**BUILDING CODE OF AUSTRALIA
ASSESSMENT REPORT**

7 Parkview Drive, Homebush Bay

Reference: J070403

Date: 6 November 2009

3 NORTH ELEVATION_MASTER PLAN
1:500

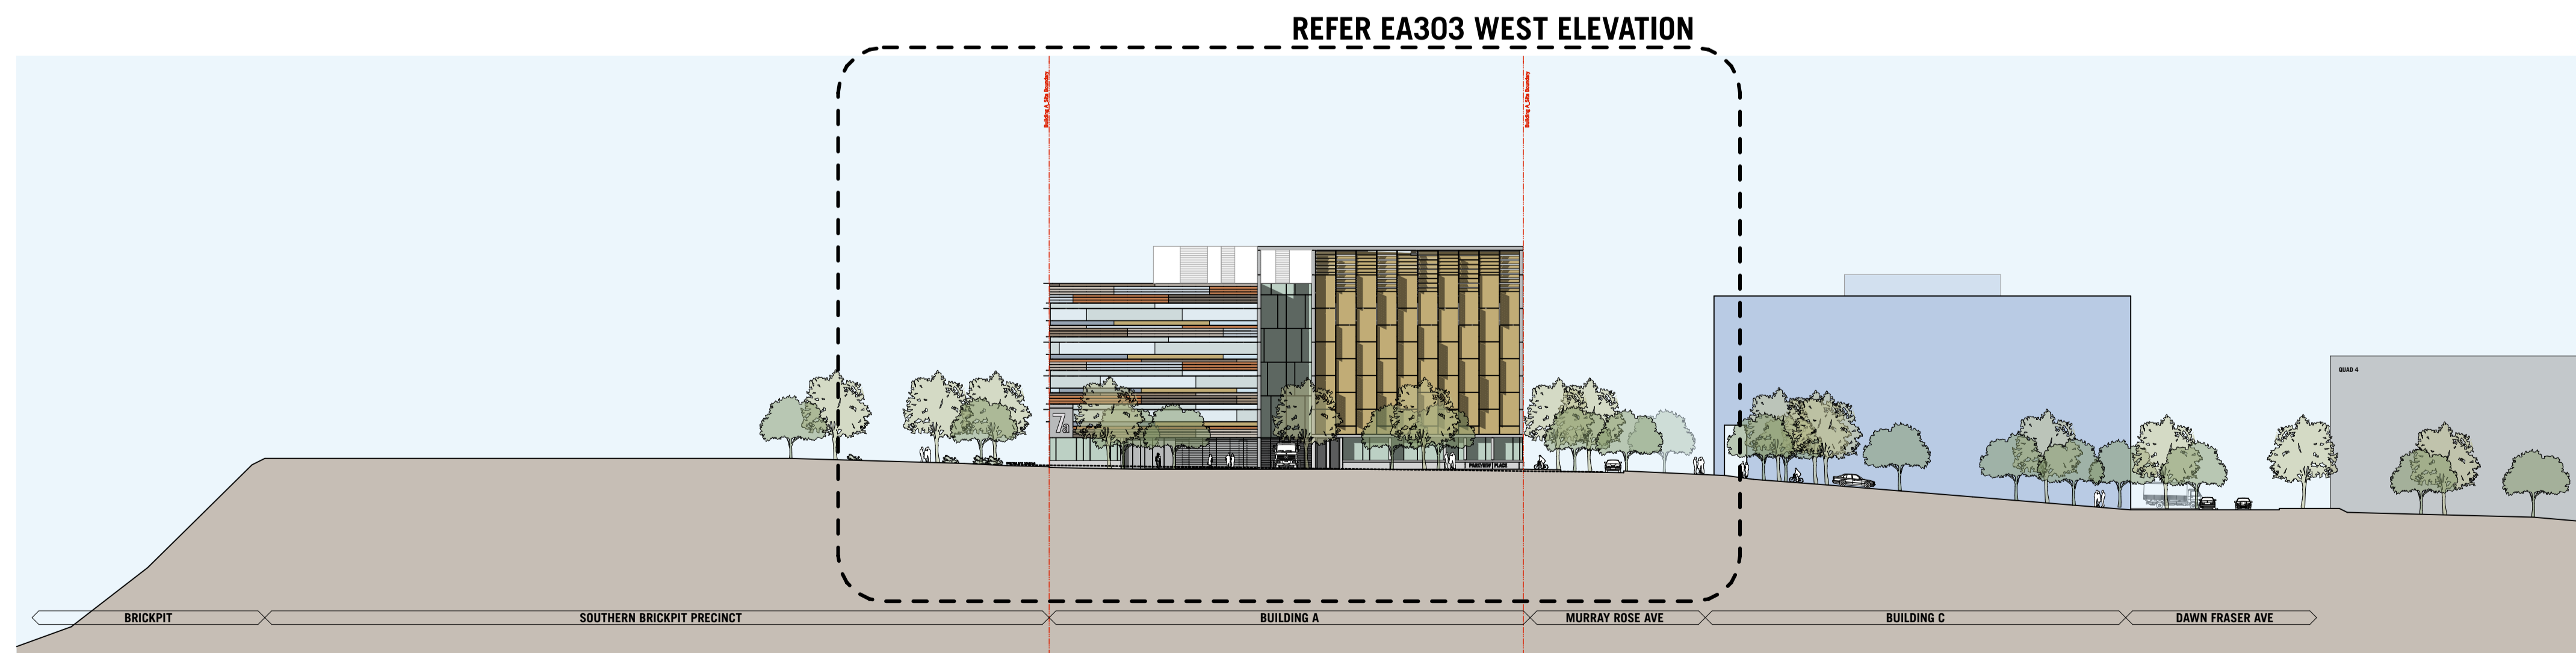
- (i) The building contains window openings adjacent to the western property boundary (North elevation) that must be protected to the requirements of Clause C3.4. Those window openings incorporate more than 1/3rd of the area of the façade of the storey in each case.

- (v) The windows adjacent to the western property boundary (North elevation) must be protected to the requirements of Clause C3.4. An alternative solution incorporating an easement over the adjoining property in lieu of drencher protection may be verified against BCA Performance Requirement CP2

- (vi) The window openings identified above incorporate more than 1/3rd of the area of the façade of the storey in each case and as such do not comply. An alternative solution incorporating an easement over the adjoining property in lieu of drencher protection may be verified against BCA Performance Requirement CP2

The alternative solution proposed incorporates the creation of a 6m wide easement to the adjoining property, in favour of the subject property, prohibiting the erection of a building within that zone.

The effect of the easement is to create a clear space between the subject building and any potential adjacent fire source feature that is at least equivalent to that which would be anticipated for a building achieving compliance with BCA Part C3.

1 Basement 02
1:500

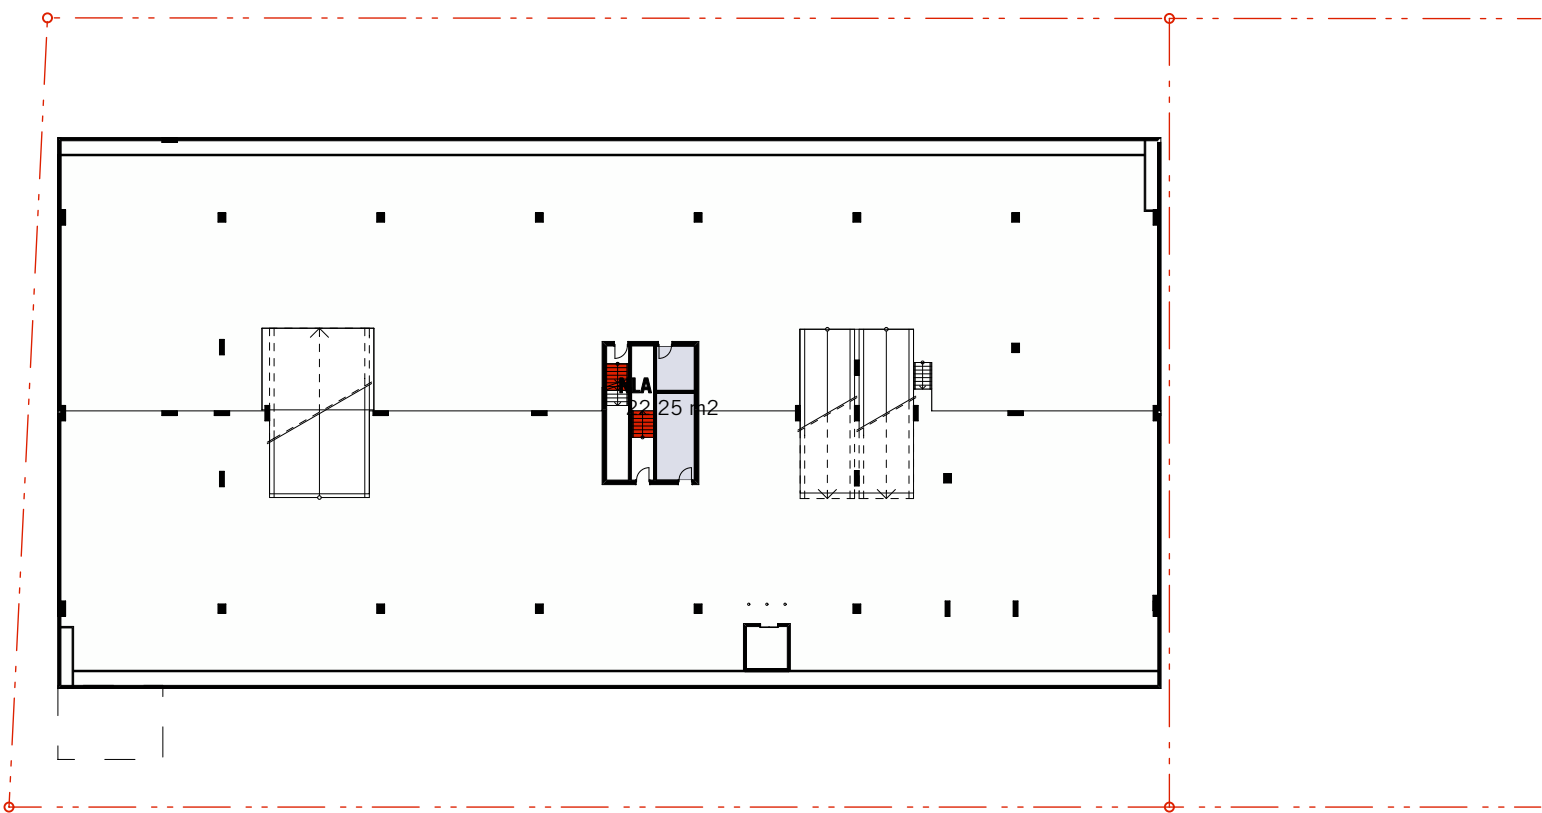
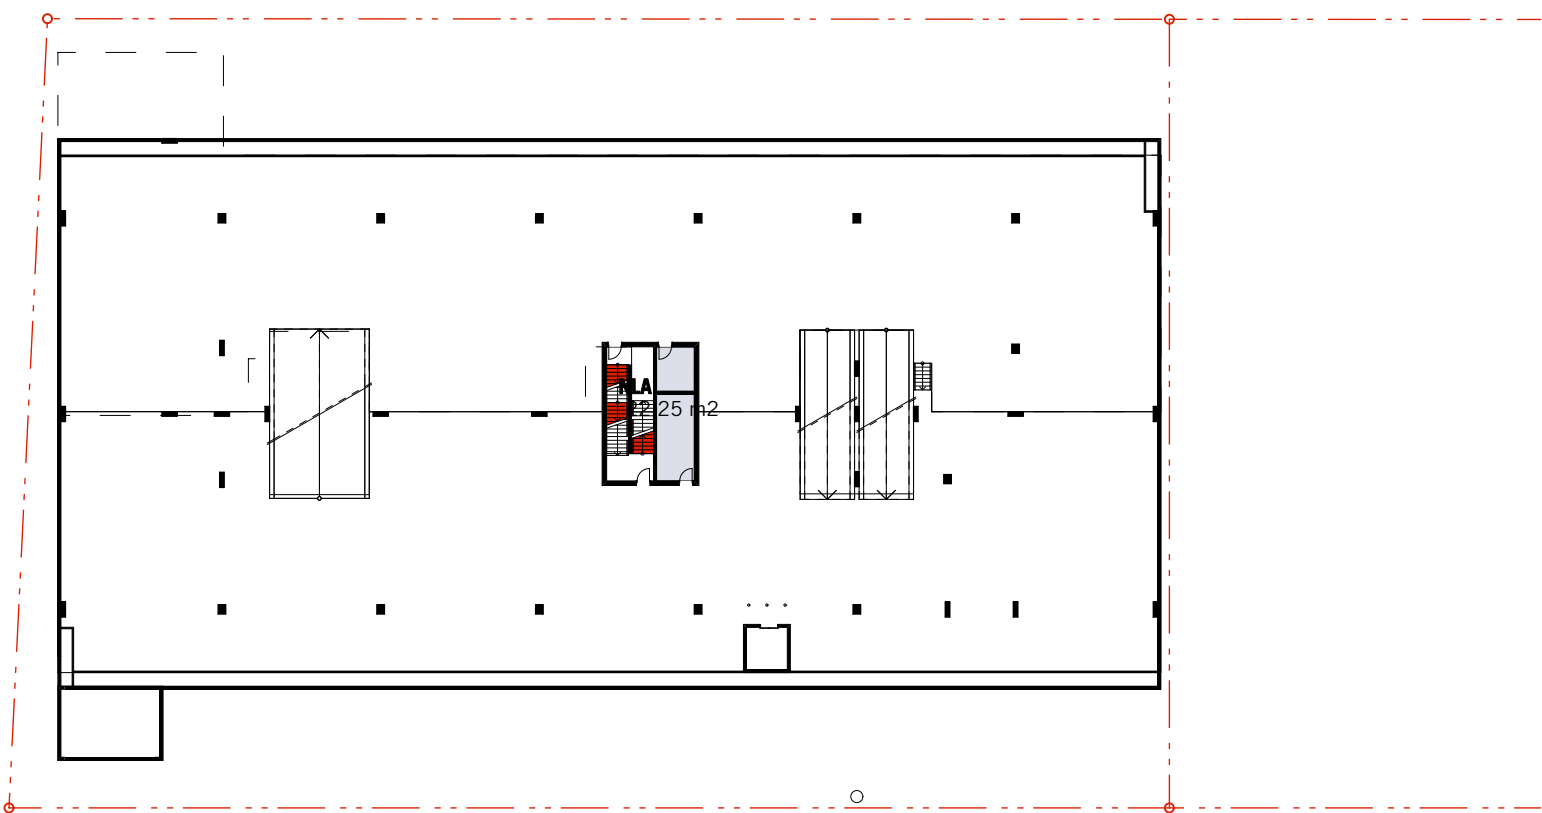
- (ii) The distance from the southern end of basement levels 1 & 2 to a point where travel is available in different directions to alternative exits exceeds the permissible 20m.

- (vii) The distance from the southern end of basement levels 1 & 2 to a point where travel is available in different directions to alternative exits exceeds the permissible 20m. To address this issue it will be necessary to provide a stairway connecting the split portions of each level (being RL5.0 connected with RL6.4 & RL7.8 connected with RL9.2). That stairway should be in the vicinity of the vehicle ramp

- a) The reduction of the Required Safe Egress Time with the provision of fast response sprinklers in lieu of ordinary response sprinklers and the provision of voice annunciation to the Occupant Warning System. This variation provides an earlier and clearer warning to occupants enabling them to evacuate the building earlier than would otherwise be anticipated.
 - b) Provision of additional directional signage to ensure that occupants are aware of the location of exits at all times.
- (iii) The distance between alternative exits to the Ground floor B level exceeds the maximum permissible 60m (approximately 64m).

3 Ground Level
1:500

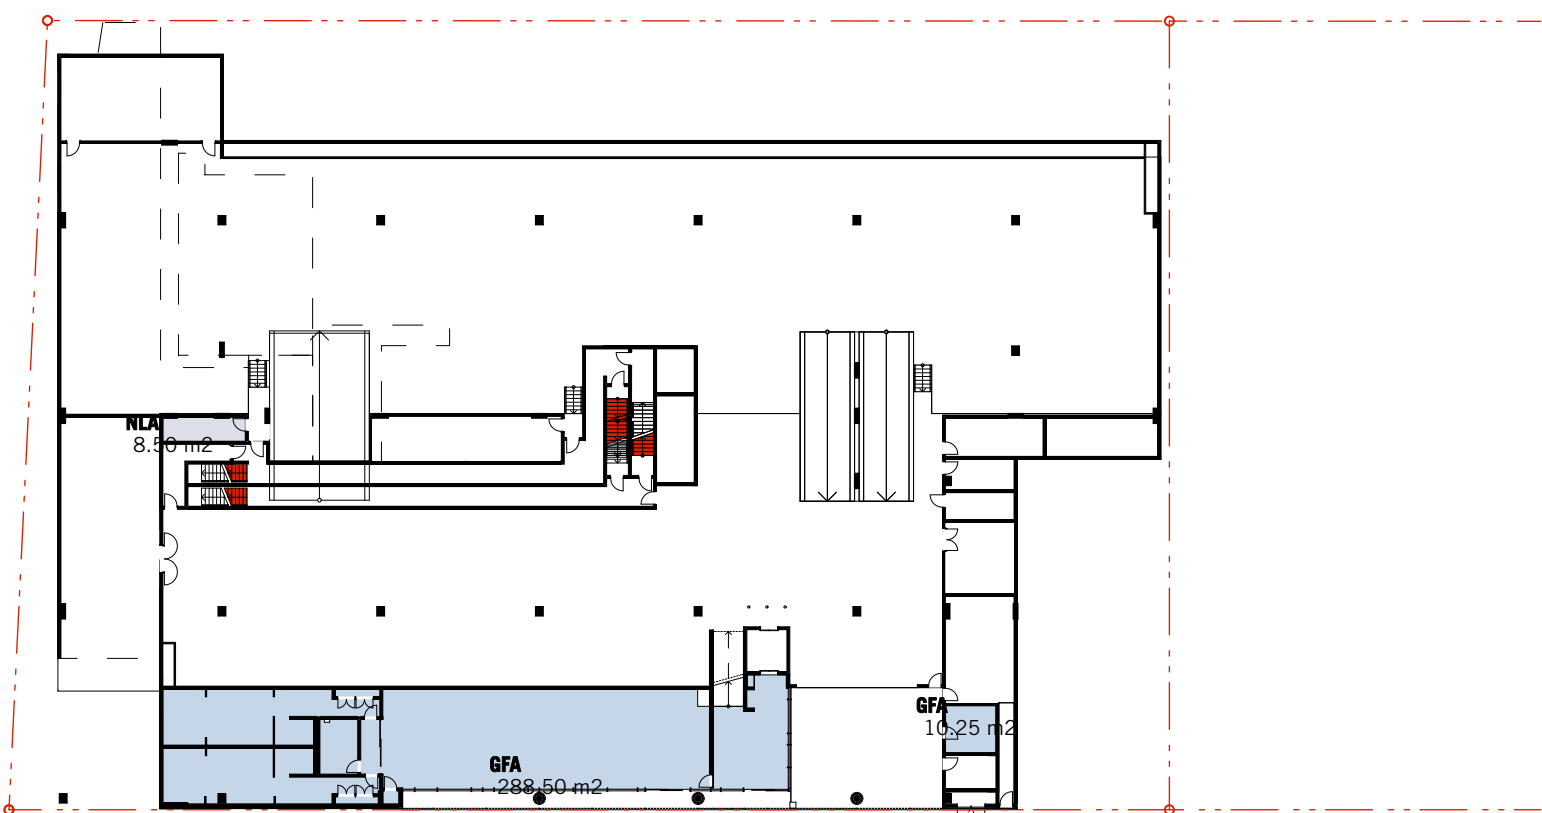
- (viii) The distance between alternative exits to the Ground floor B level exceeds the maximum permissible 60m (approximately 64m). To address this issue it will be necessary to provide a stairway linking Ground floor A & Ground floor B in the vicinity of the lift pit or the southern side of the northern vehicle ramp. Alternatively, it may be possible to verify the current design as an alternative solution under BCA Performance Requirements DP4 & EP2.2.

- c) The reduction of the Required Safe Egress Time with the provision of fast response sprinklers in lieu of ordinary response sprinklers and the provision of voice annunciation to the Occupant Warning System. This variation provides an earlier and clearer warning to occupants enabling them to evacuate the building earlier than would otherwise be anticipated.

- d) Provision of additional directional signage to ensure that occupants are aware of the location of exits at all times.
 - e) An additional point of egress has been provided to the fire isolated passageway to the northern side of the carpark. Whilst this exit is not an alternative exit for the purposes of the BCA, it provides occupants with an additional point of egress from that area of the building.
